16 April 2026

UPG Wickham Pty Ltd
Suite 110, Level 1
180-186 Burwood Rd
BURWOOD NSW 2134

Pre-Development Application No:	PR2026/01016 (SSD-89869959)
Land:	Lot 1 DP 1197377
Property Address:	10 Dangar Street Wickham
Proposed Development:	Construction of a 43-storey (plus plant) mixed use tower, comprising residential apartments, co-living apartments, ground floor retail, hotel component and concurrent rezoning proposal via a SSD application.

# Ground Floor & Public Domain Plan

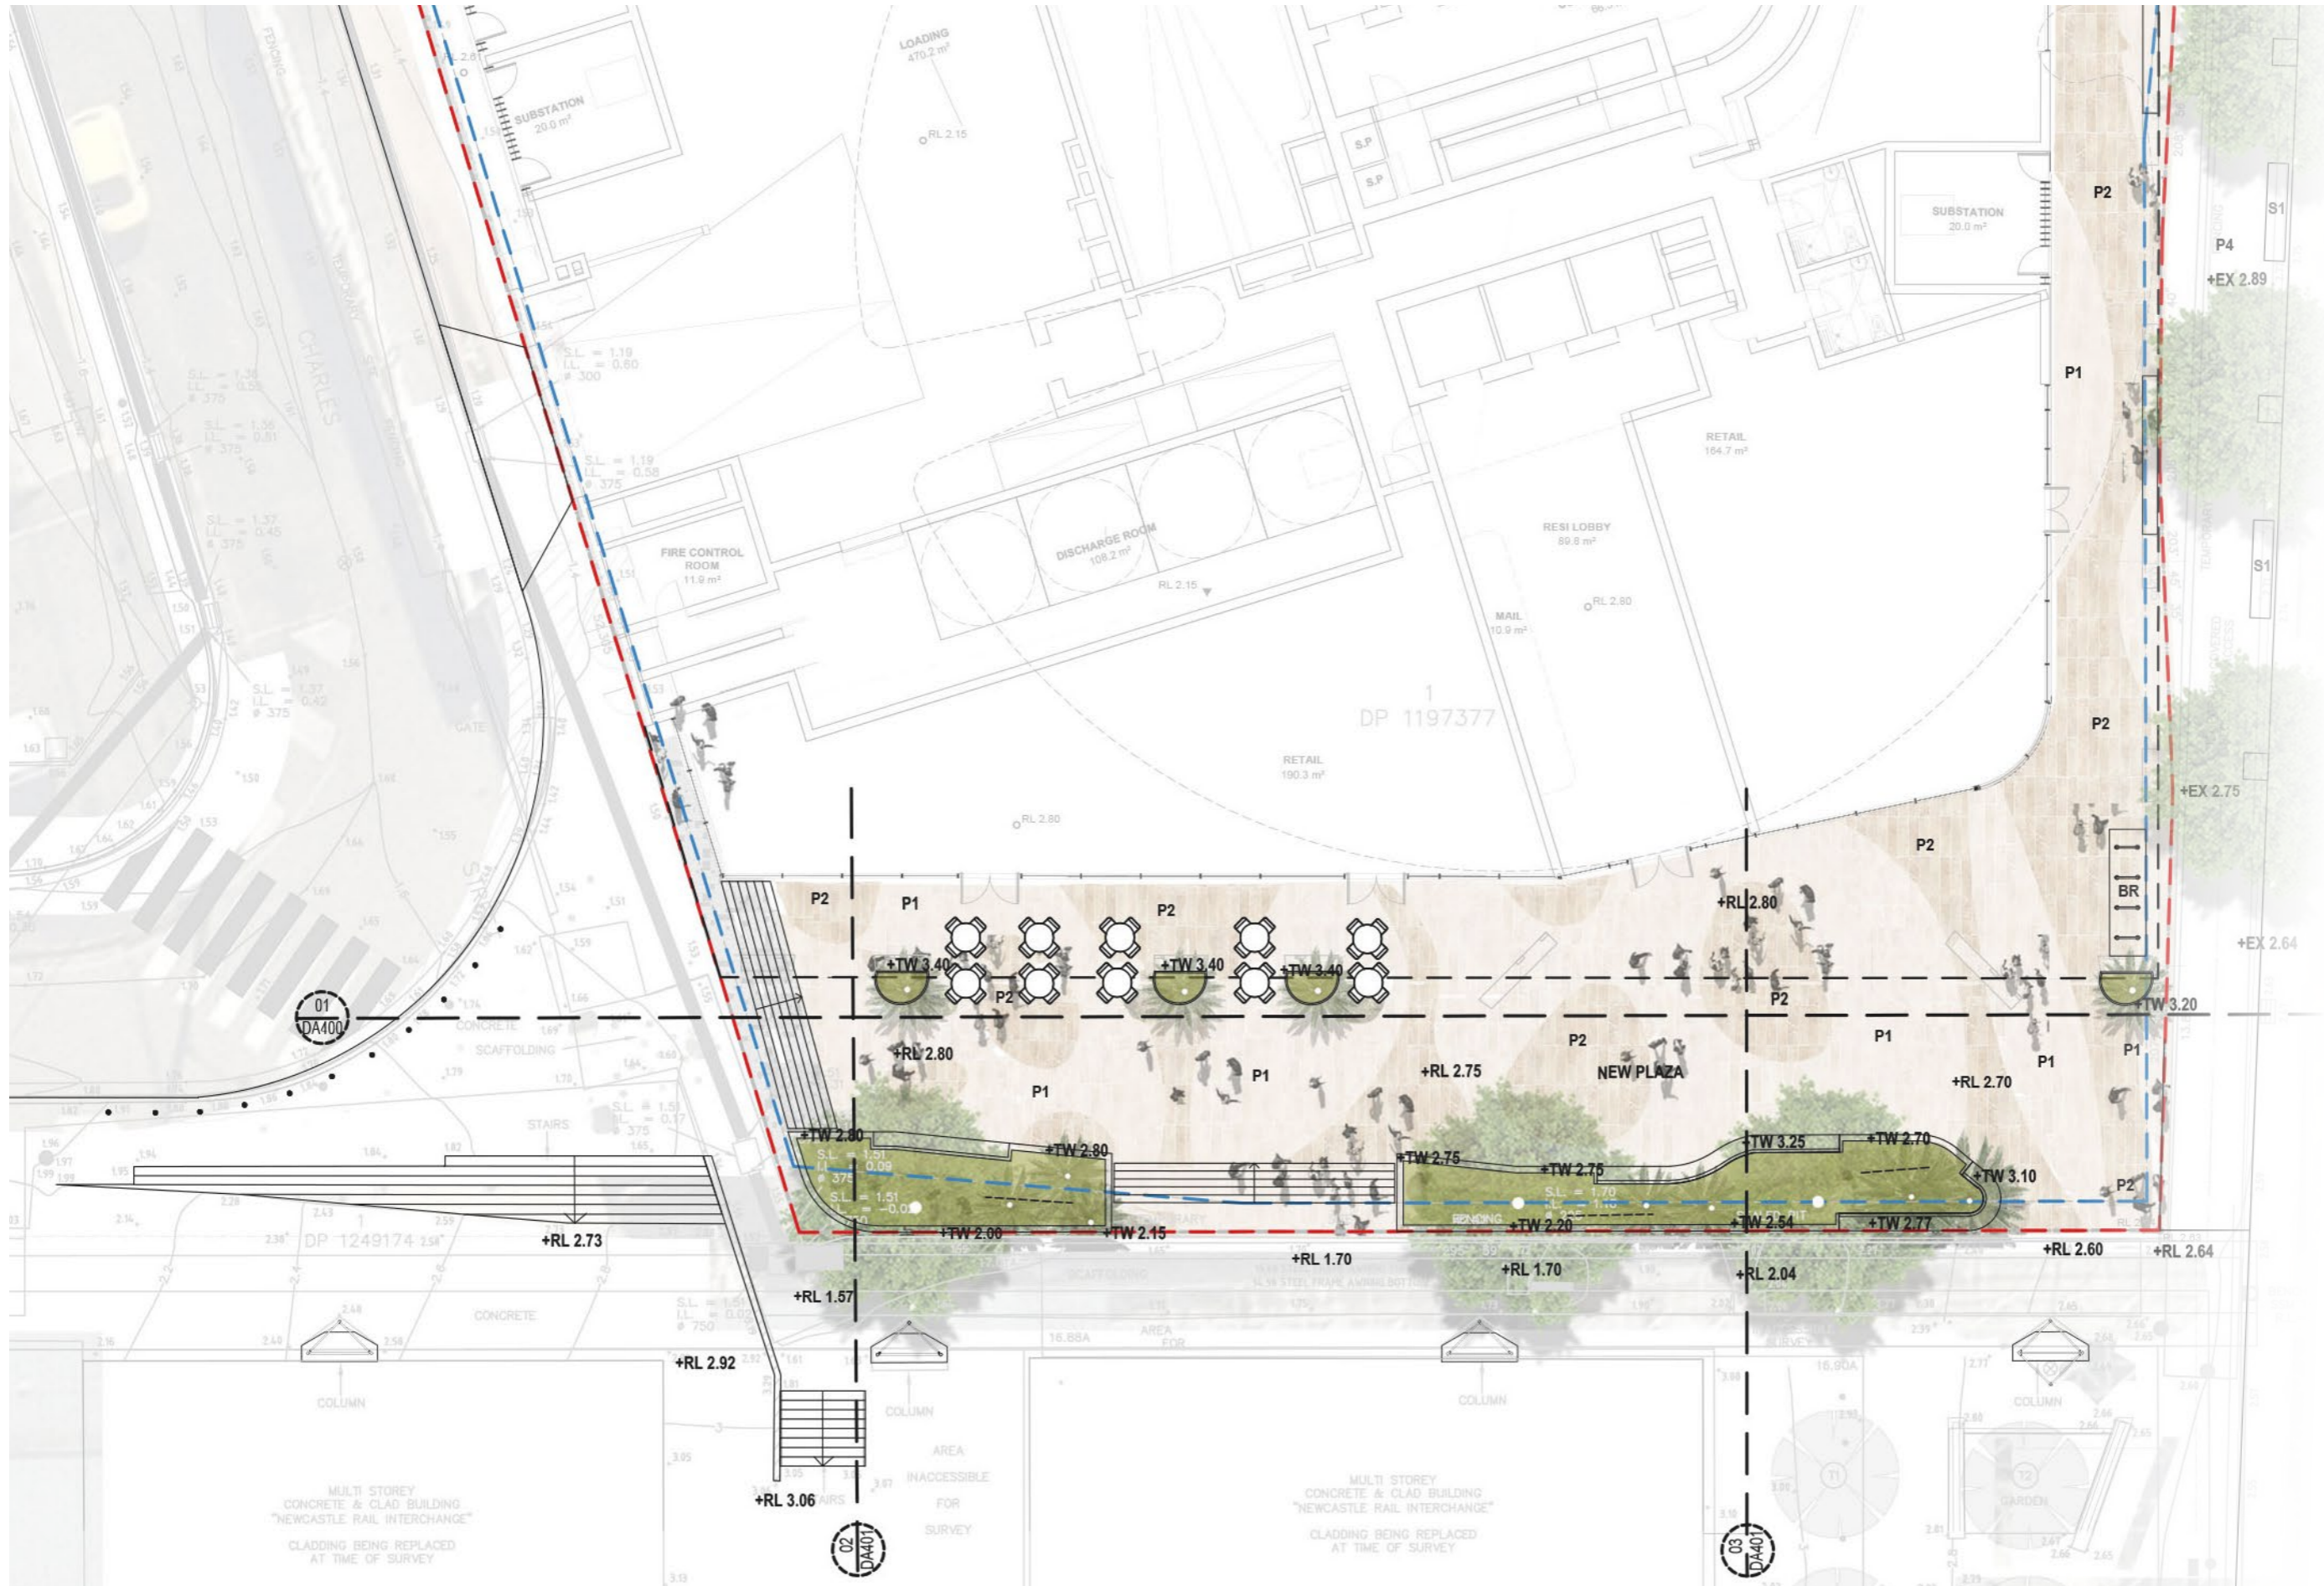
- a) Dangar St southwest driveway for the loading dock seems to be within a critical location and the following concerns are raised.
 - HRV movements to/from Charles St into/out of the Dangar St loading dock driveway may pose added risks to other road users (noting that a two-way cycleway will be required on Dangar St as per Wickham Public Domain Plan).

- The southwest loading dock driveway location does not meet AS2890.1 Figure 3.1 compliance based on existing kerb alignment.
- b) All three proposed driveways do not meet AS2890.1 Figure 3.3 minimum sightlines compliance requirements, and compromises safety at the driveways and footway areas. Splays must be provided in accordance with Australian Standards.

- At the corner of Dangar St/Charles St, the Ground Level building footprint extends to the property boundary. Proposed building design compromises sightlines and safety at this corner for pedestrian, cyclist and vehicles.

- Setbacks and splays are recommended.
- c) There are doors to the west of the loading dock and basement driveway on Dangar St driveways and a door on the north of Charles St driveway. Safety concerns are raised as the doors will lead pedestrians directly onto the driveway area and hinder sightlines.

- d) The public domain streetscape proposal has not been endorsed by CN. Dependency on the kerb extensions and footpath widening to achieve compliance for driveway locations and sightlines compliance are not supported. (Note: flooding constraints also affect the road areas).

- e) Dangar St driveways are approx. 6.5 – 7m in width with overall length of over 13.5m. Dangar St is to be designed as a civic street, with cyclist and pedestrian amenity. Thus, the driveways and vehicular traffic generated by this development will generally dominate Dangar St at street level.

- There are a number of doors opening onto the road reserve, which poses danger to pedestrians and added risks. Doors must be designed to fully be located and opening within the site and must not encroach on the public road reserve.
- Handrails and tactile measures associated with the private steps at the Charles St/Station St and Dangar St/Hannell St interfaces will require redesign to avoid unduly encroaching over the road reserve. The design must be amended to address these impacts.

Concern is raised that Dangar Street will be dominated by vehicles (esp. HRV and service vehicles). This will be exacerbated in terms of streetscape where roller security gates for the basement access and the loading dock roller gate (at 4.5m height) are proposed.

- CN require that alternative driveway design options should be explored which mitigates impacts to streetscape and dominance of driveways in a civic street.

- CN requires that the development be redesigned to not place high dependency on streetscape works to achieve Australian Standards compliance for driveways and sightlines requirements.
